Application Reference: 2025/0143

Location: 22 Windhill Drive, Staincross, Barnsley, S75 5BL.

This application seeks planning permission for the erection of a wrap-around extension comprising a two-storey side extension with a first floor Juliet balcony to the rear and single storey rear extension adjoining an existing single storey rear extension with a new mono pitched roof. The proposal shows that a larger driveway would also be created to the front.

| Job No. - Dwg No.   | HJ/2023/11C   | -        |

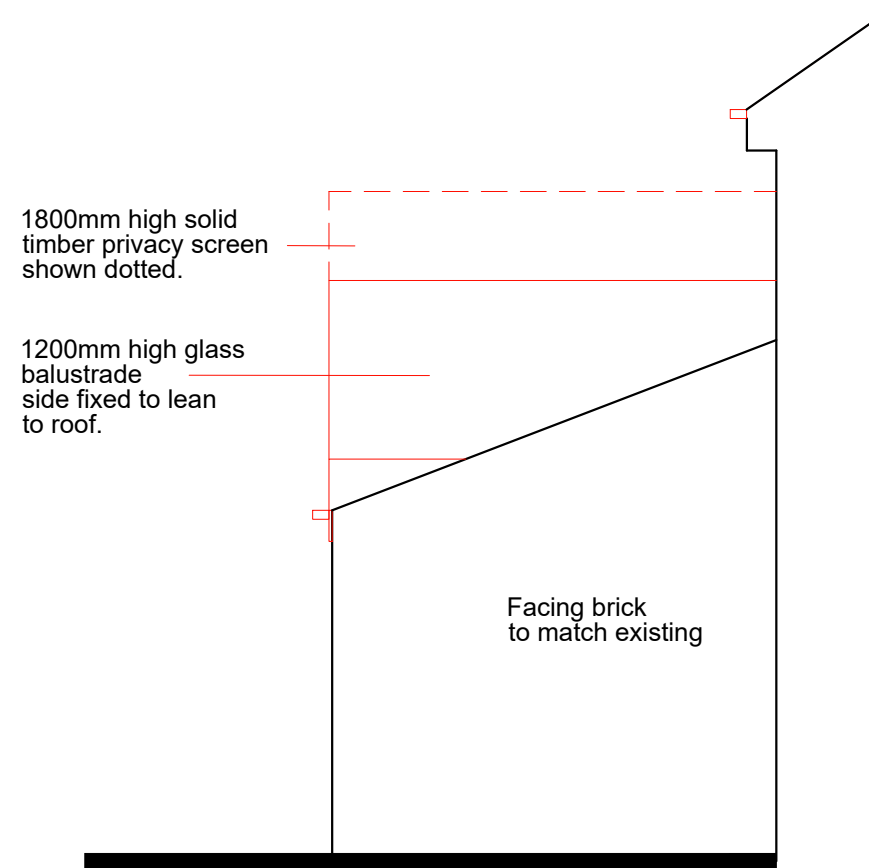
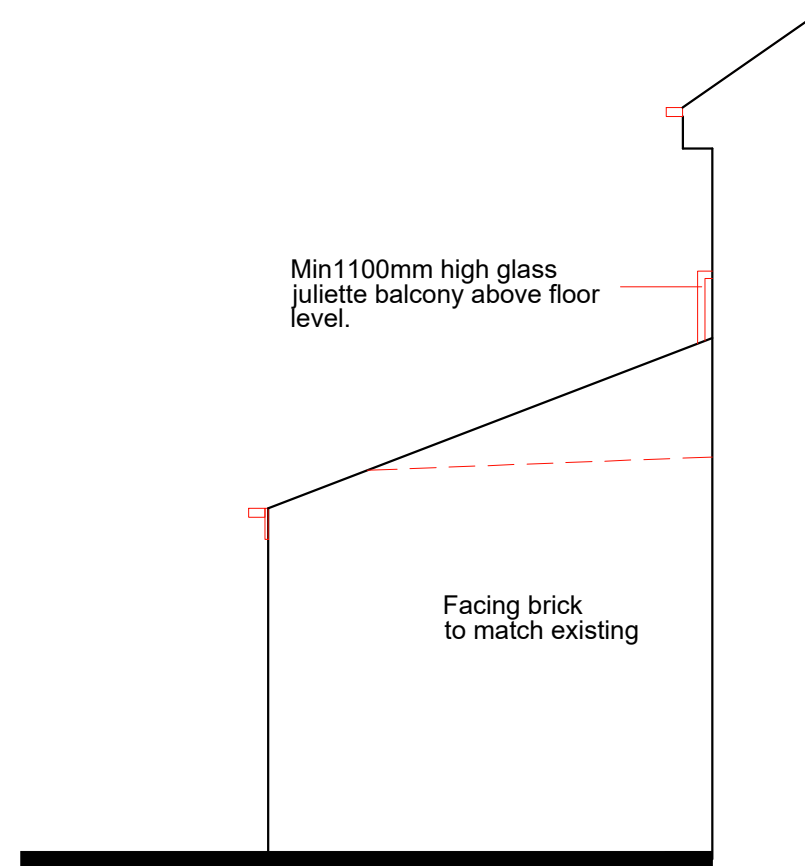
During the application process, the proposal was amended to remove a first-floor balcony to the rear and replacing it with a Juliet balcony. The eaves of the two-storey side extension were also reduced to the existing eaves height and provide a set down from the existing ridge.

- Remove a first-floor balcony due to concerns regarding overlooking and loss of privacy.
- Reduce the eaves height of the two-storey side extension to maintain the existing eaves height and provide a set down from the existing ridge.

HJ/2023/11C Proposed Side Elevations Rev. C received 16th June 2025
